Online Comment

Application H16-1099-22
Location 33 RED LION STREET SPALDING PE11 1SX
Proposal Installation of photovoltaic panels to south & west roof slopes

Name Greg Watkinson
Address Conservation Officer

WEST ELEVATION - PROPOSED

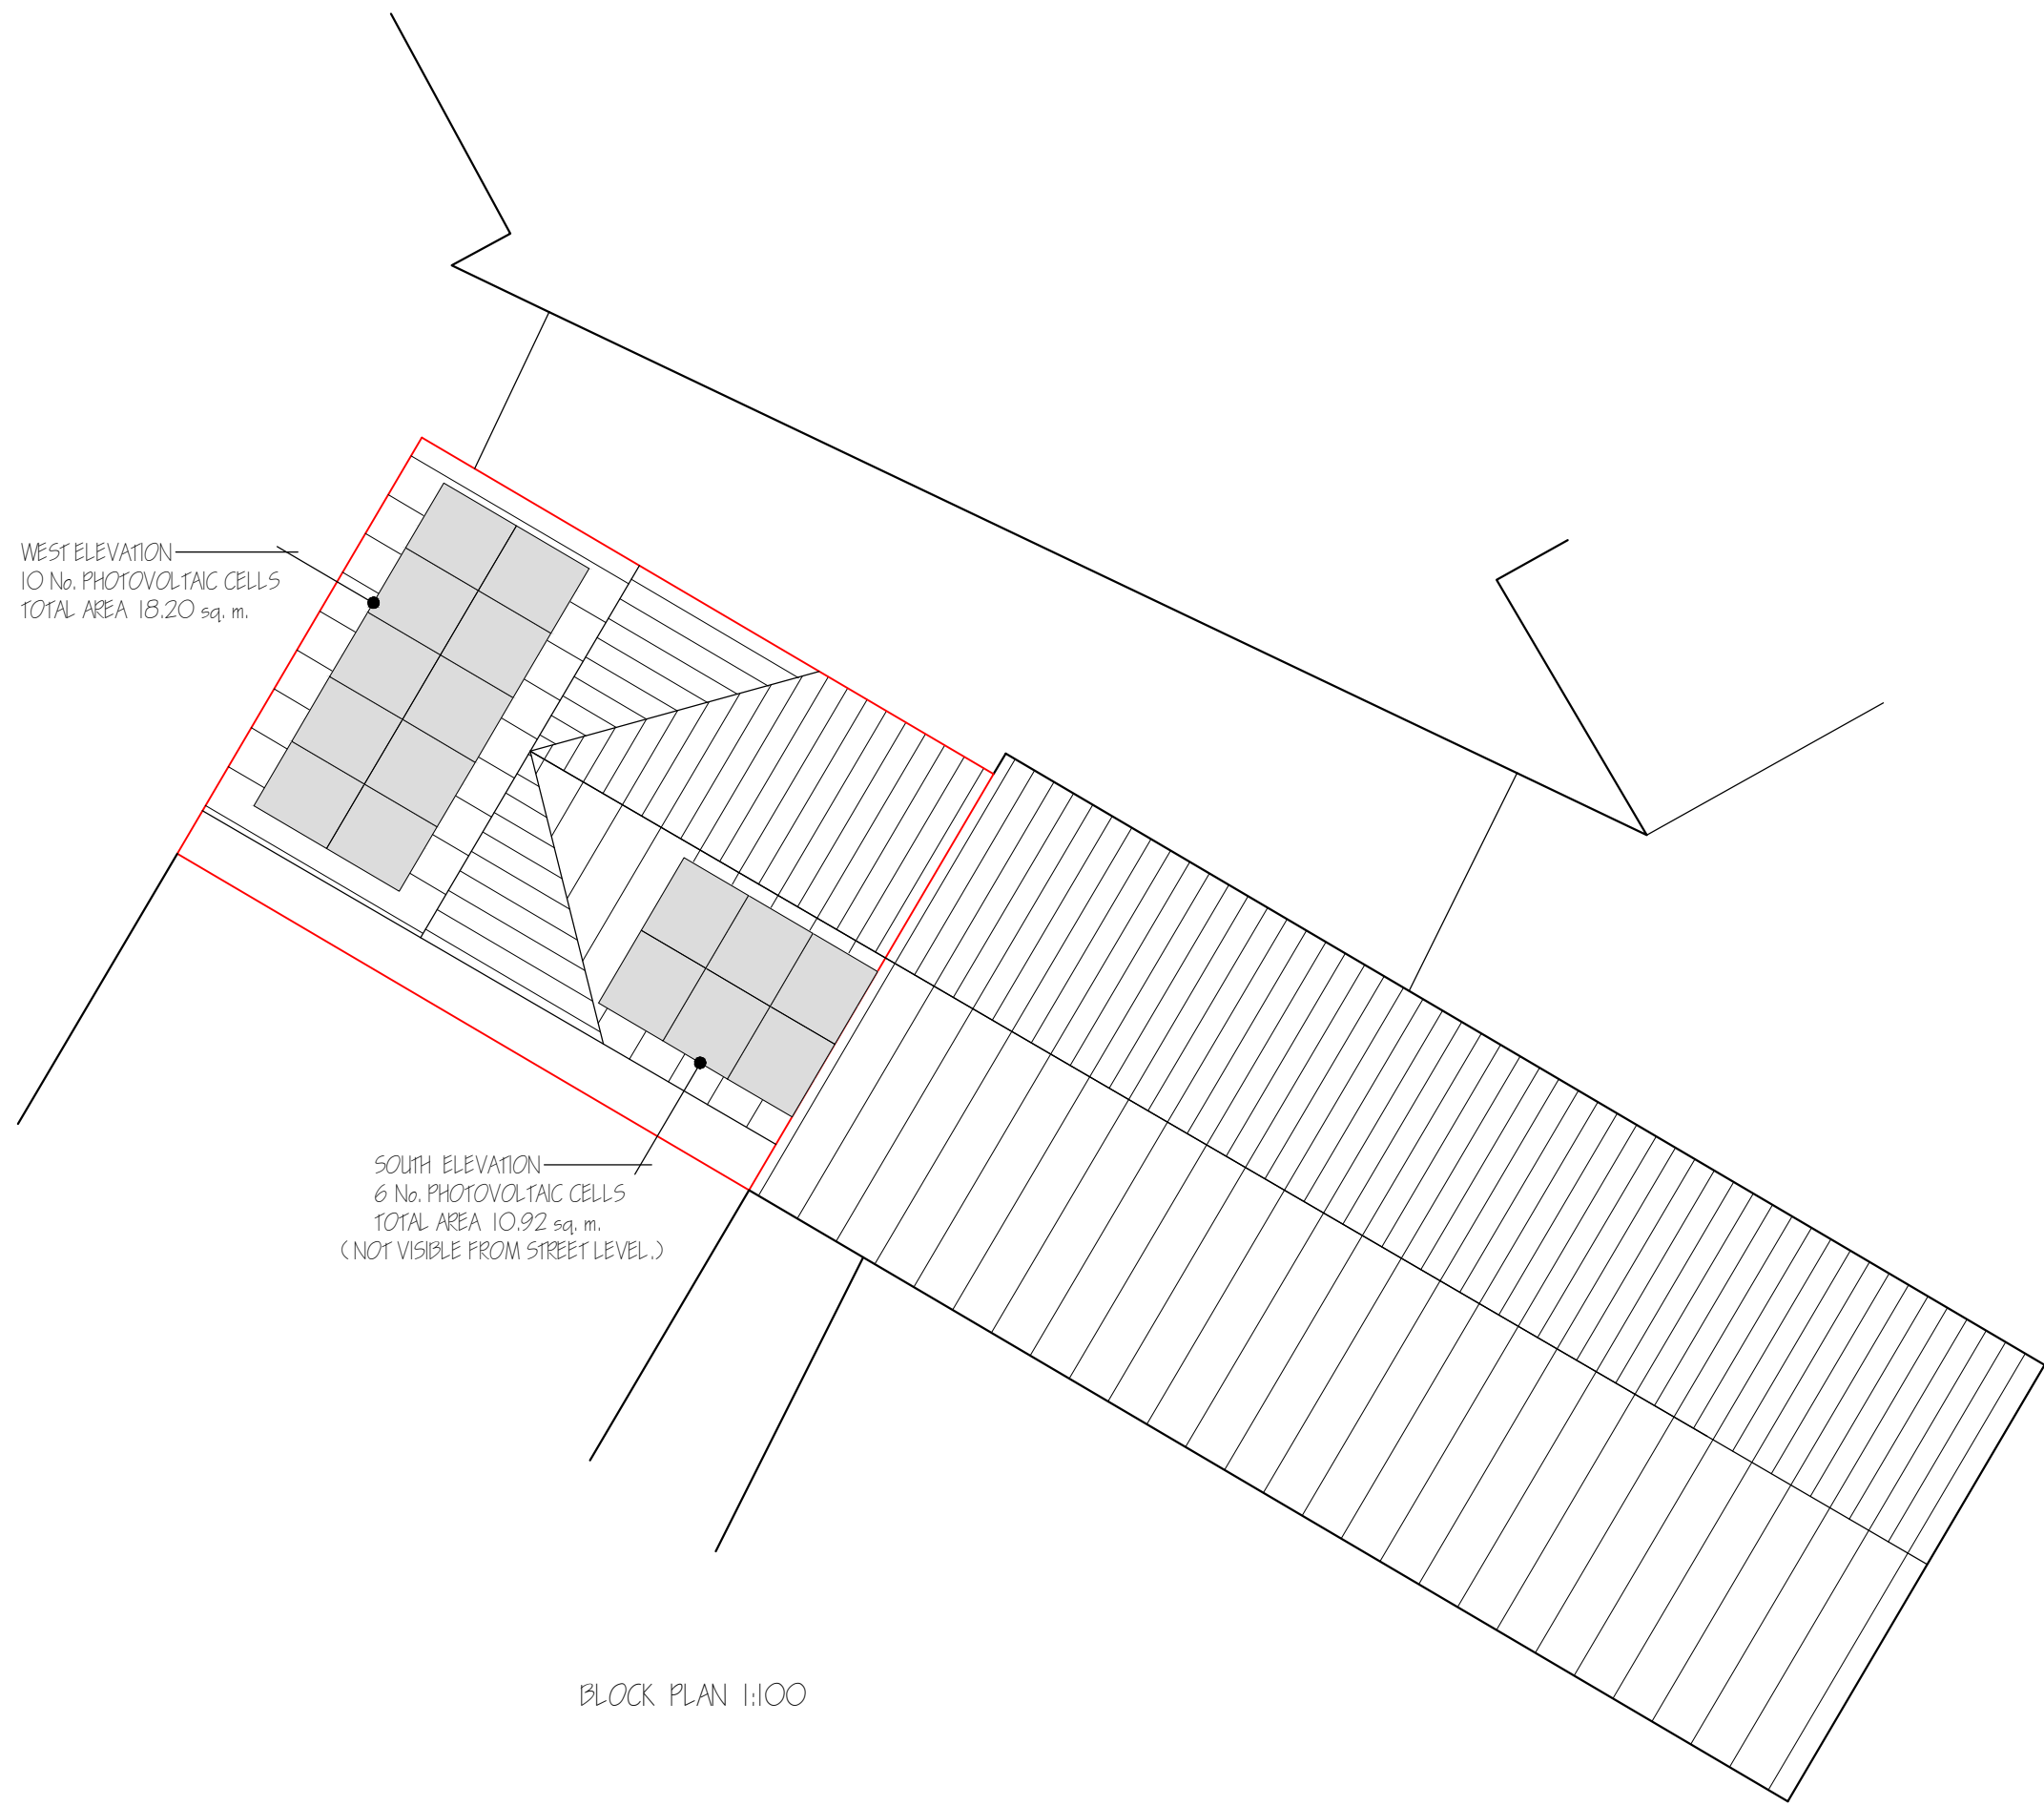
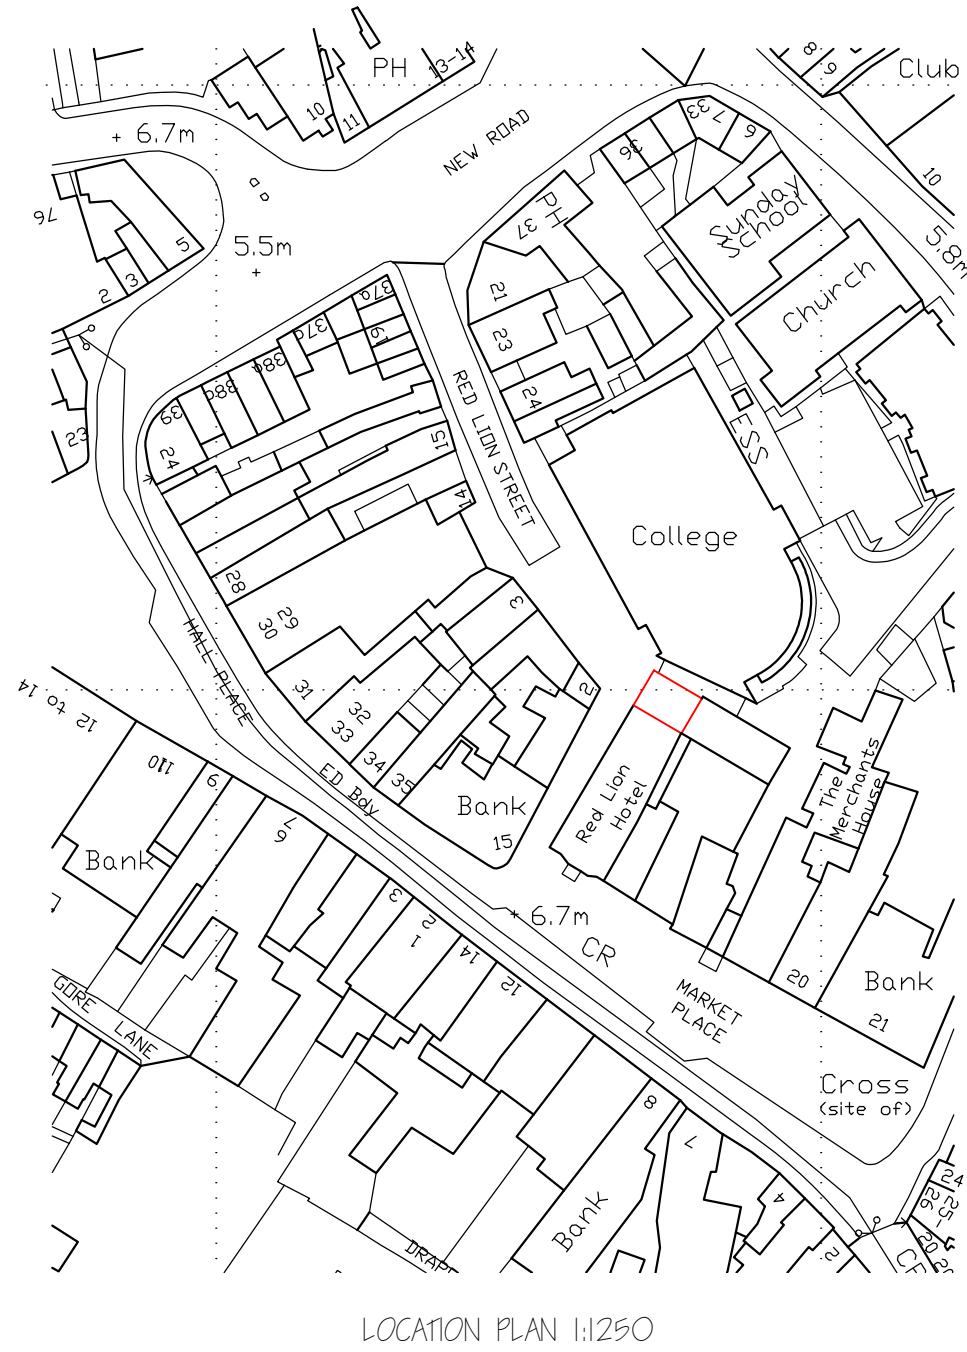
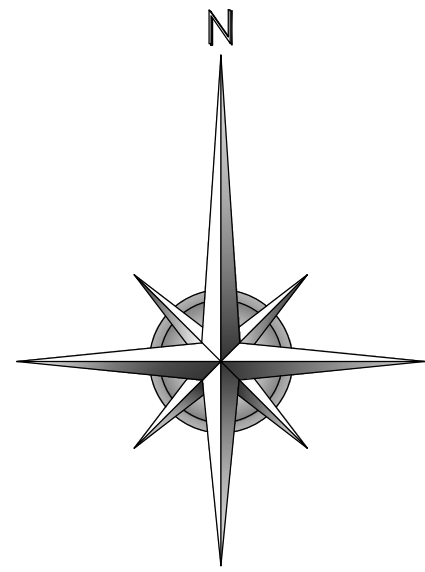
This proposal, by virtue of it's intention to place modern photovoltaic cells on a highly visible elevation within a prominent section of the conservation area, fails to respect the standard of visible materials within this portion of the town centre and the slate roof of the host property, which is a common feature of this section of the Conservation Area.

Furthermore, the proposal does not seek to do anything to mitigate against the effect the proposal would have on the roofscape within the conservation area. The addition of photovoltaic cells would represent an unwieldy and highly visible addition to the rooftop and would risk generating a precedent of incongruous additions to visible roof pitches even within sensitive locations within the town centre and conservation area. The deployment of Photovoltaic within the conservation area may be possible, however, it would generally be expected that in all but exceptional circumstances, photovoltaic cells should be restricted to sections of roof not visible from the public realm or at least areas where the visual impact upon public realm views would be mitigated against.
